From: Nick Hopper [REDACTED]
Sent: 07 June 2019 10:59
To: Maria Tomalova
Subject: Re: FP/32/19/PL, 107 Felpham Way

As promised I have checked your proposal and I have to inform you that some of the proposed flats would not provide the adequate living conditions for future occupiers with regards to outlook and daylight.

FIRST FLOOR (Proposed) @ 1:100

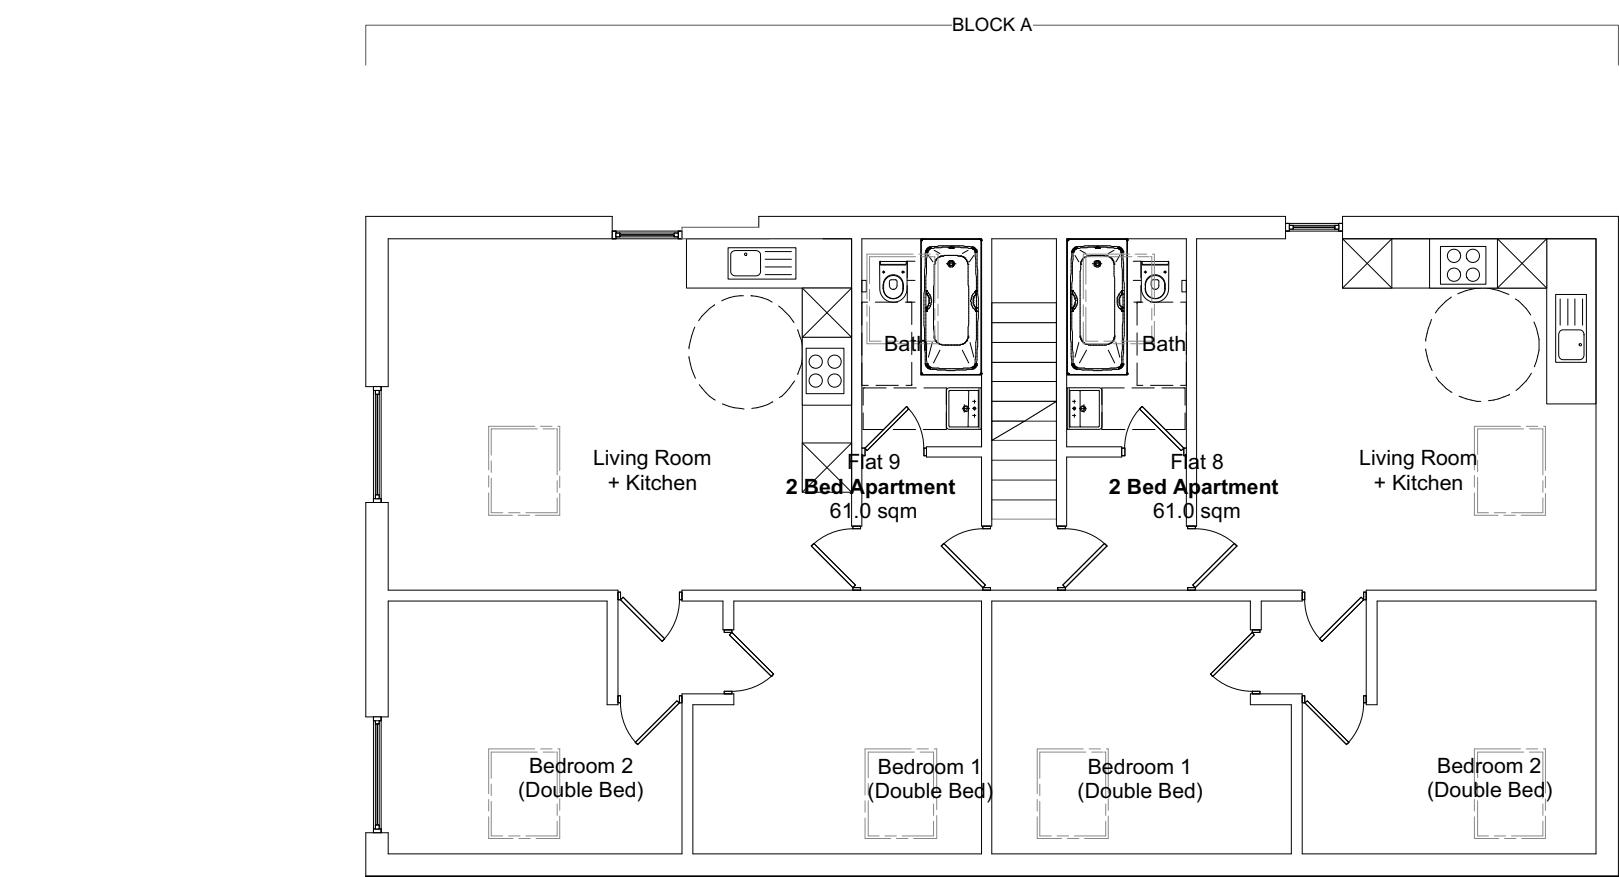
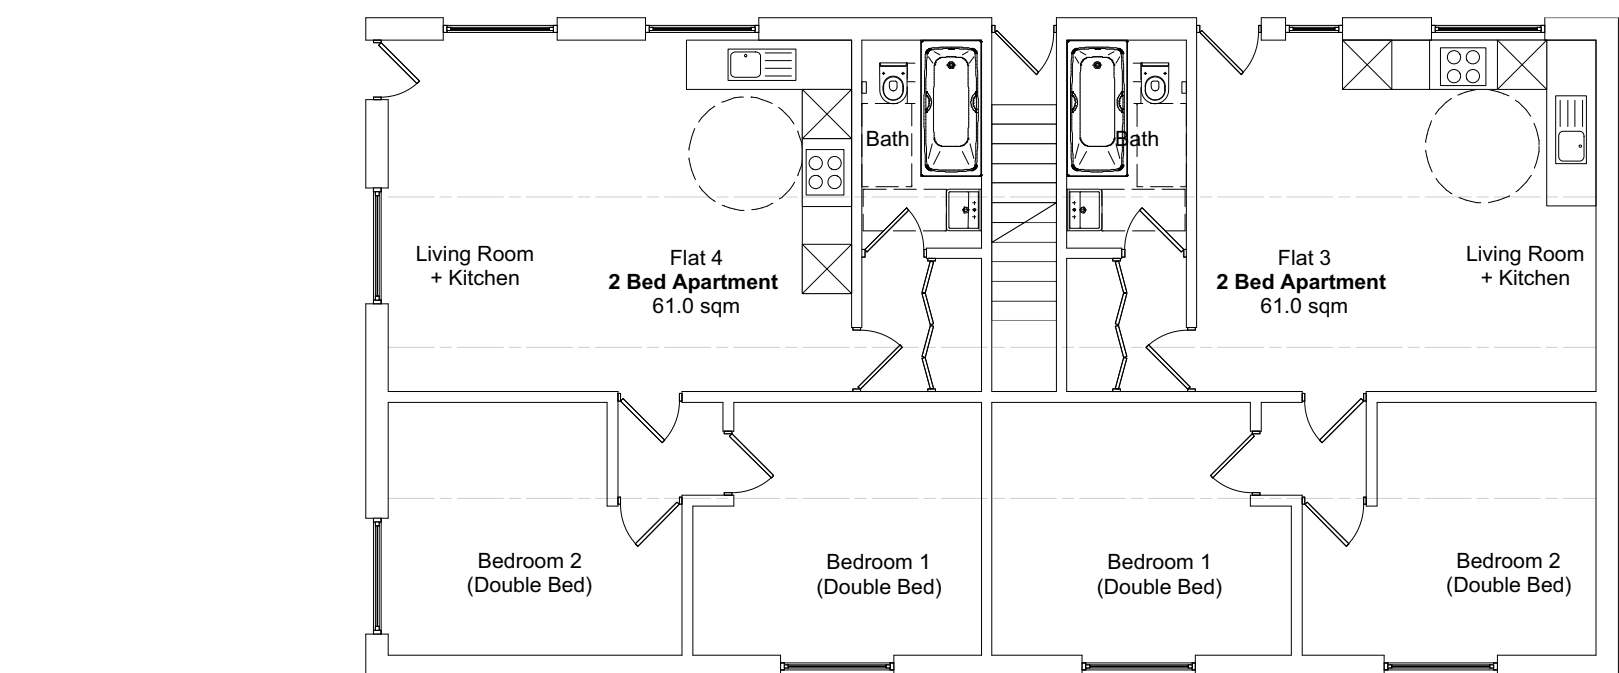
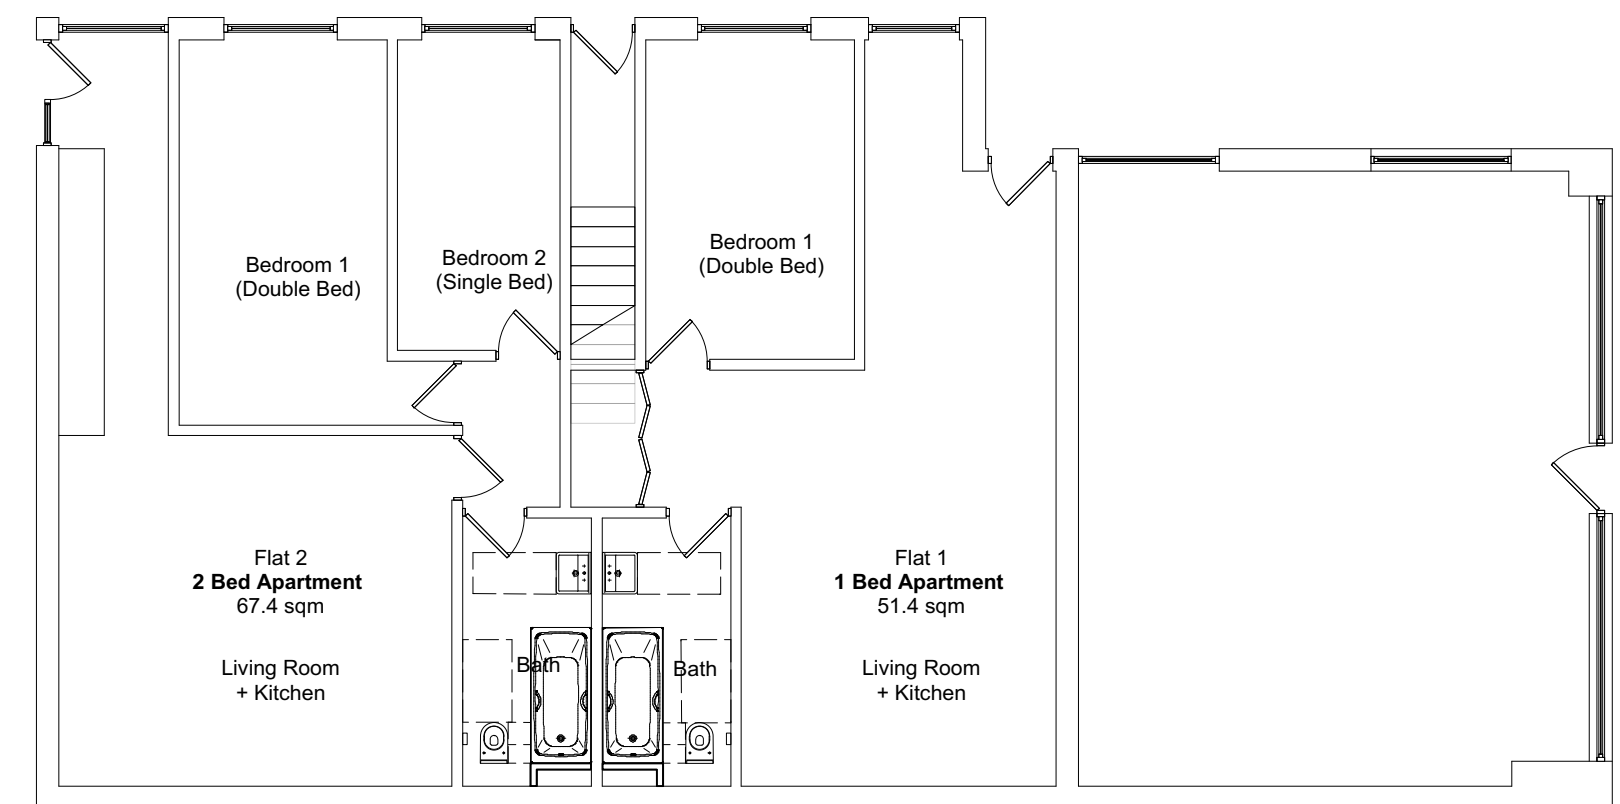
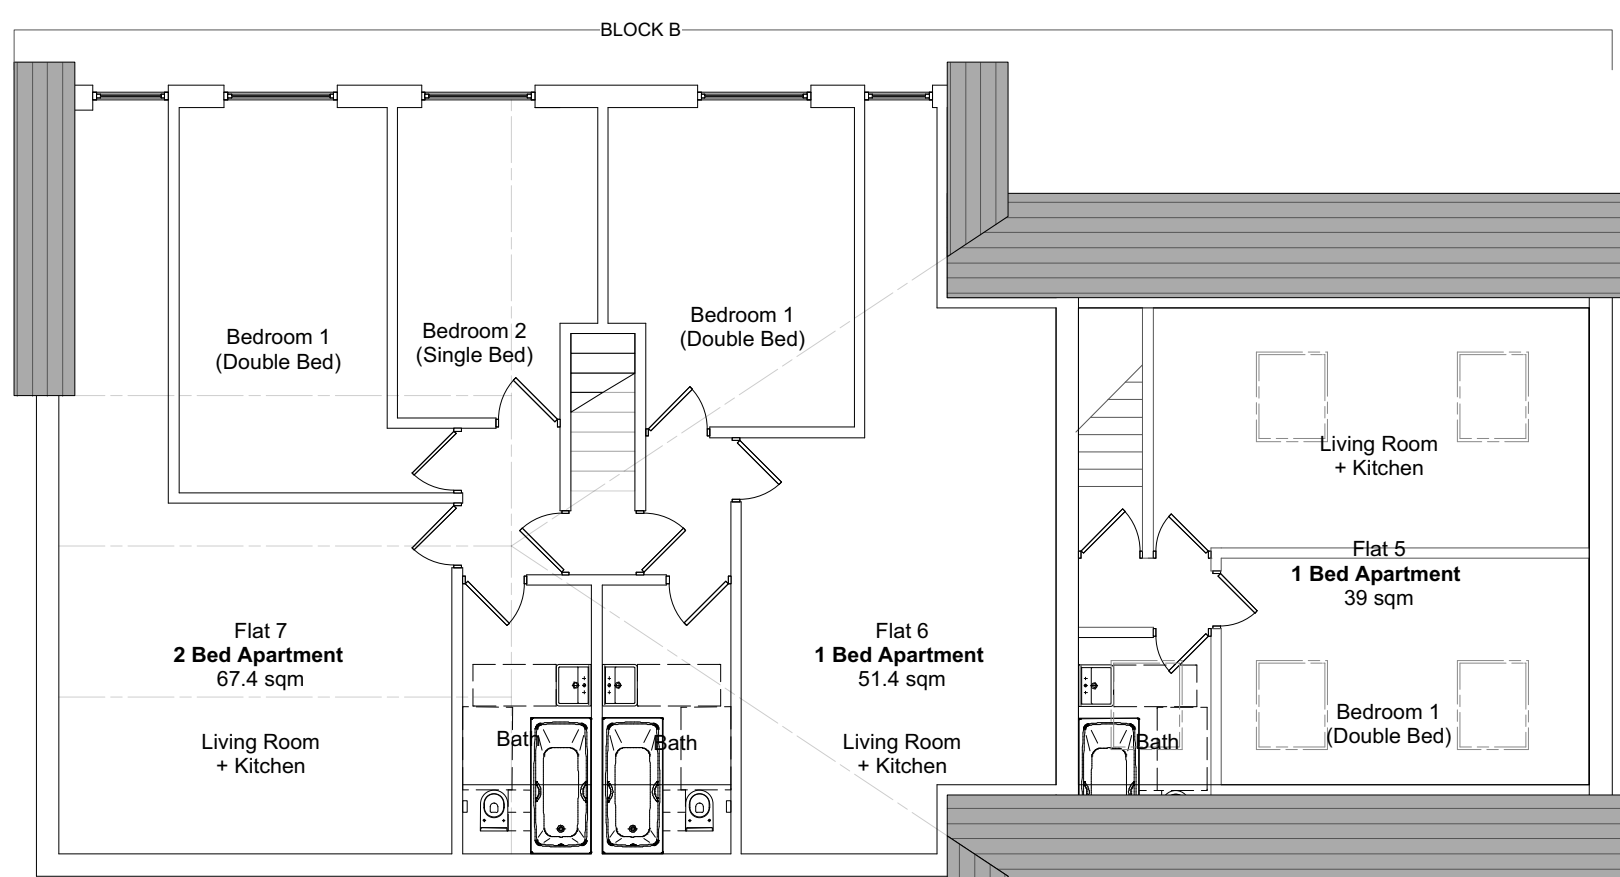
Flat 5 (first floor, block B)

1bed apartment wold be provided with roof-lights entirely lacking the outlook

Flat 6 (first floor, block B)

Inadequately lit living/kitchen area; bedroom's window would affect the privacy of first floor flat to the east.

Flat 7 the same

Flat 8 (Block A) 2 bedrooms and living/kitchen area would be provided with the rooflights

with one narrow window serving living /kitchen area only which in an addition would cause overlooking of the private gardens to the east.

GROUND FLOOR (Proposed) @ 1:100

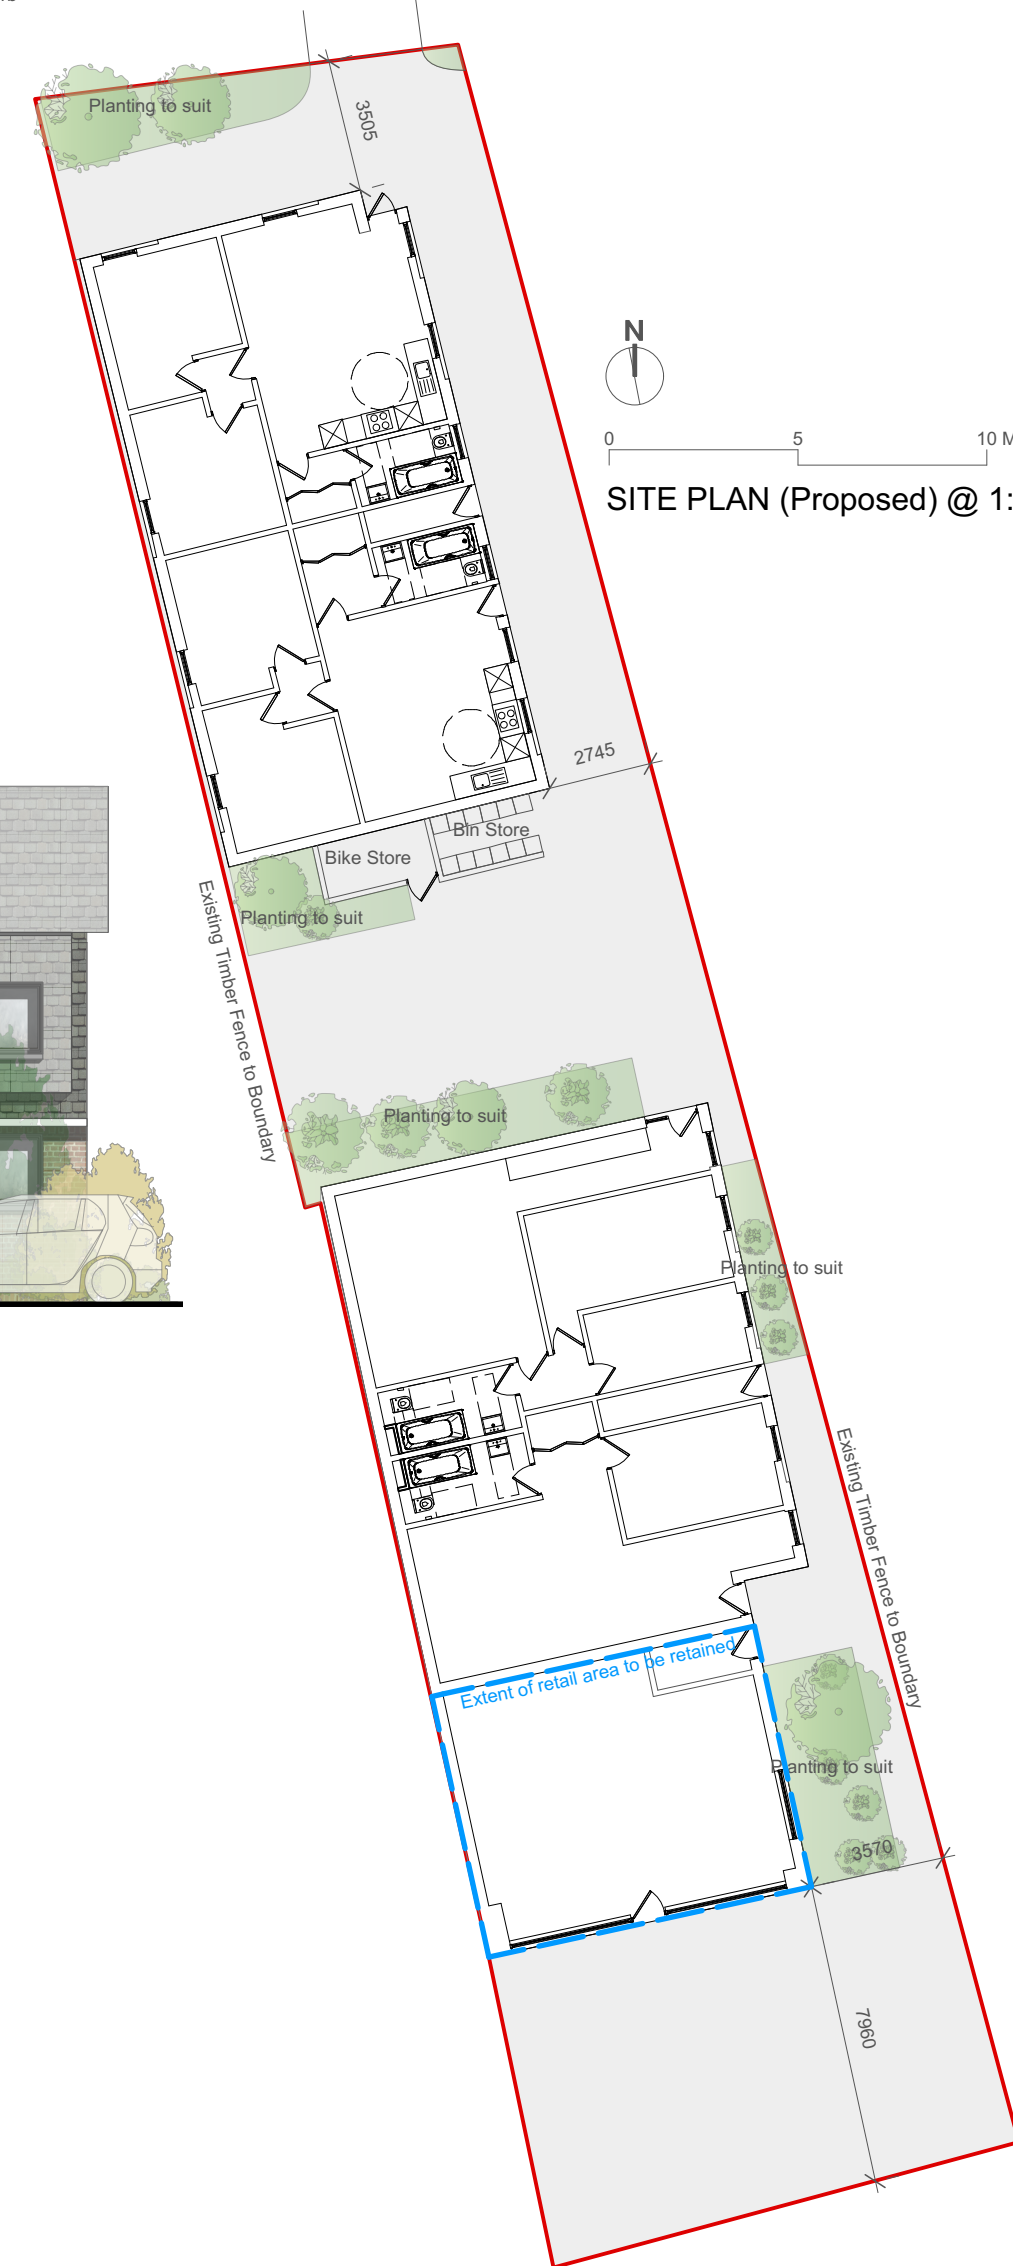
Flat 1 and 2 (ground floor)

The same apply for living rooms as above.

Bedrooms would have unacceptably compromised outlook, facing to the wall within a distance of approximately 1m.
